Your Ref: OWPC17245
Our Ref: LU/427/17/PL 21-12-2017
Please ask for:
Ross Leal

Siting of lodge style building for site office & security (resubmission following LU/141/16/PL). This application is a Departure from the Development Plan.

Castlevew Nursery Old Mead Road Littlehampton

PROPOSED FLOOR PLAN 1:50

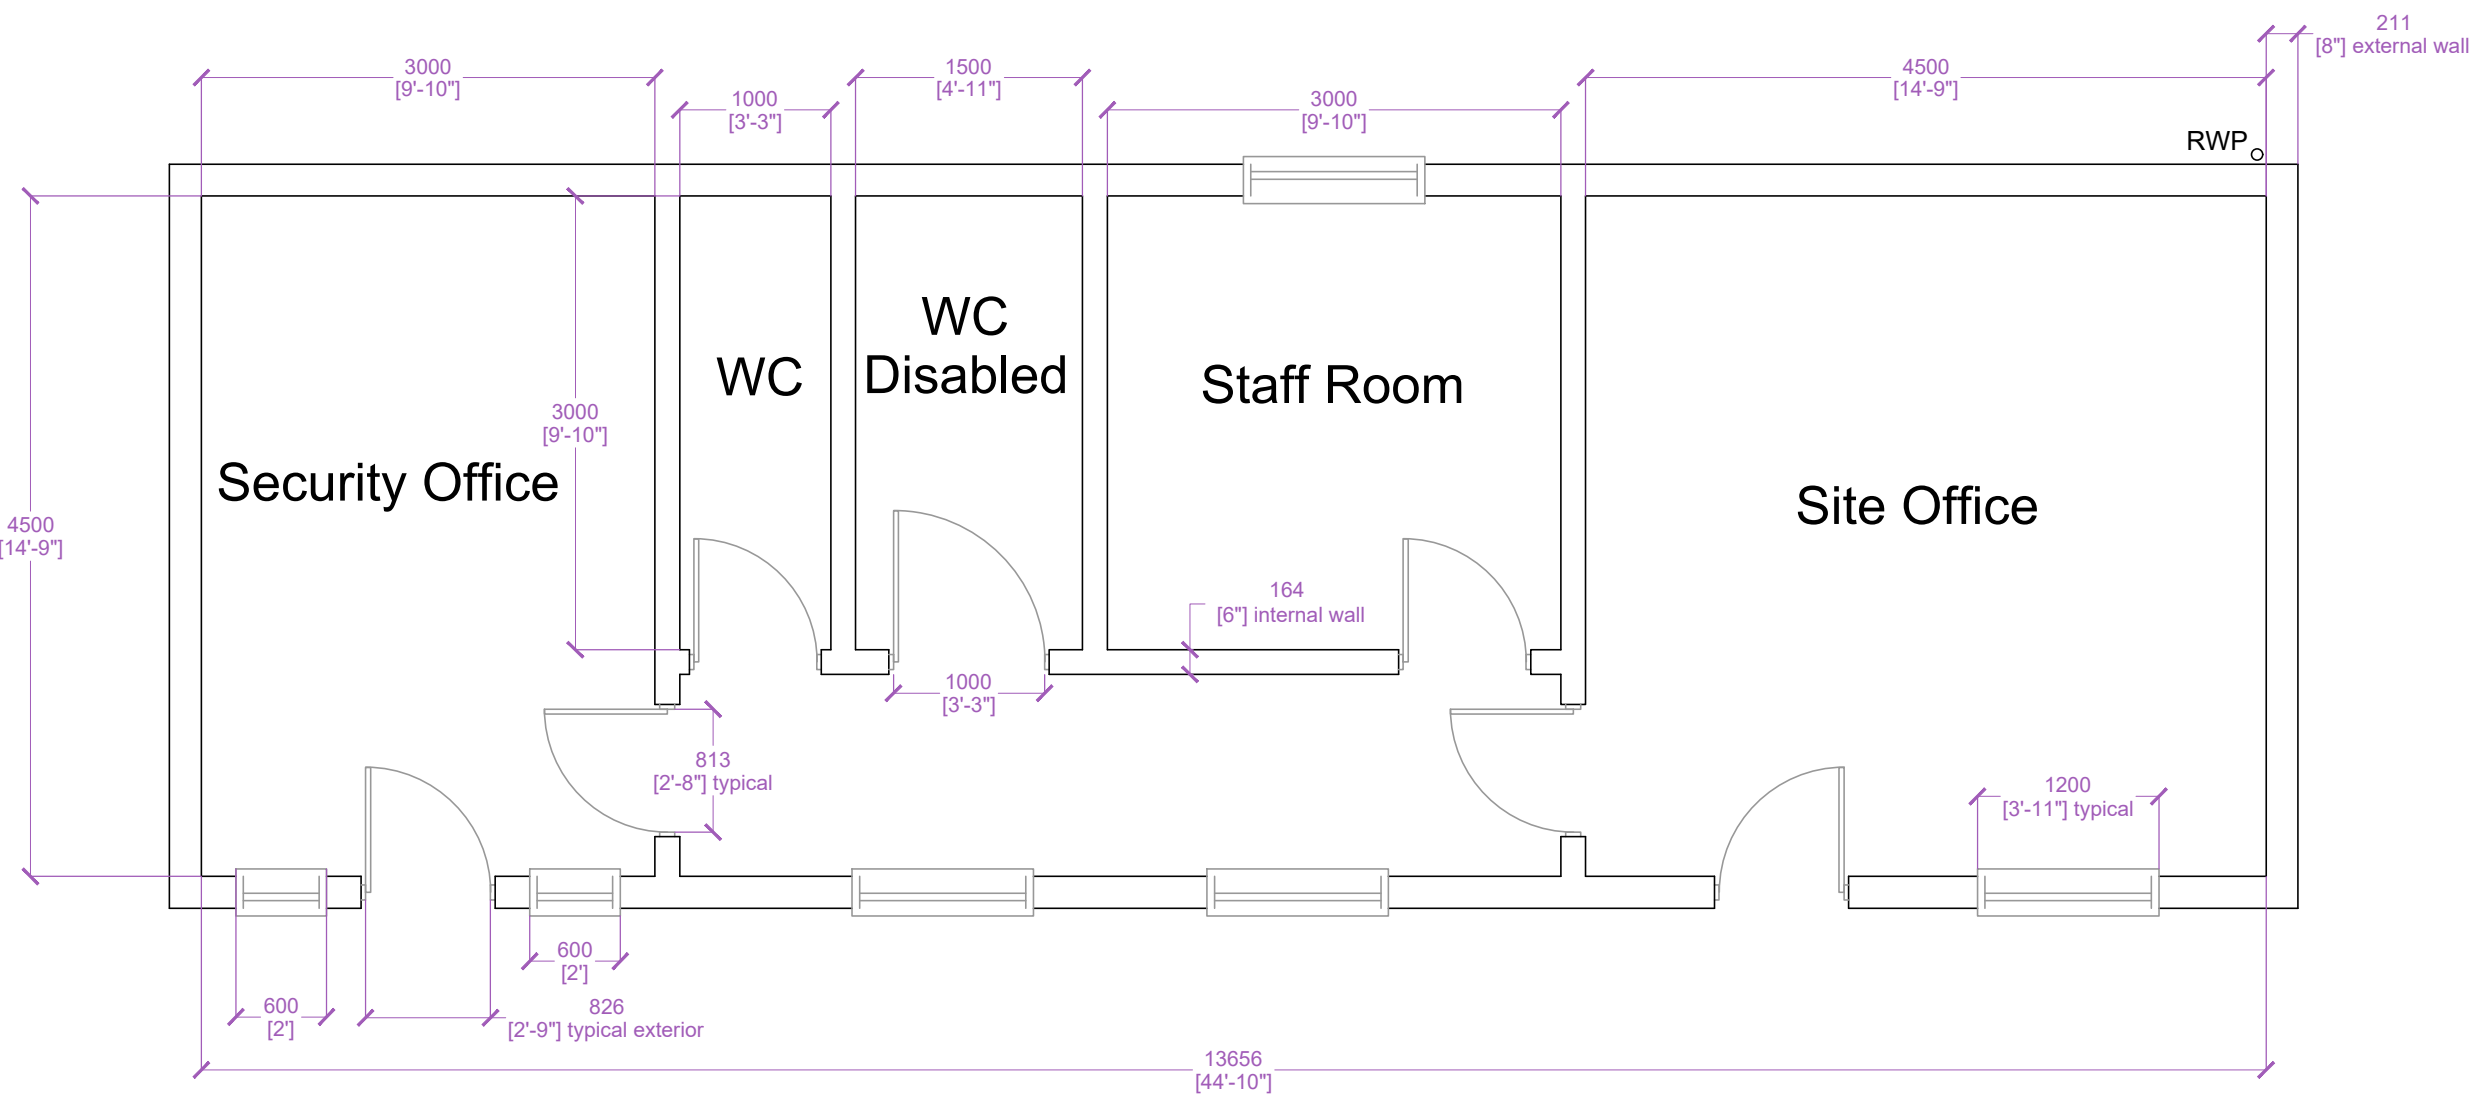
I see the size of this building is much larger than some bungalows and wonder if room of 14'9" for just 1 security worker is really needed. The rest of the property is just as big. I don't see where the waste drainage will be on the plans and it also mentions a soakaway but I don't see where it is.
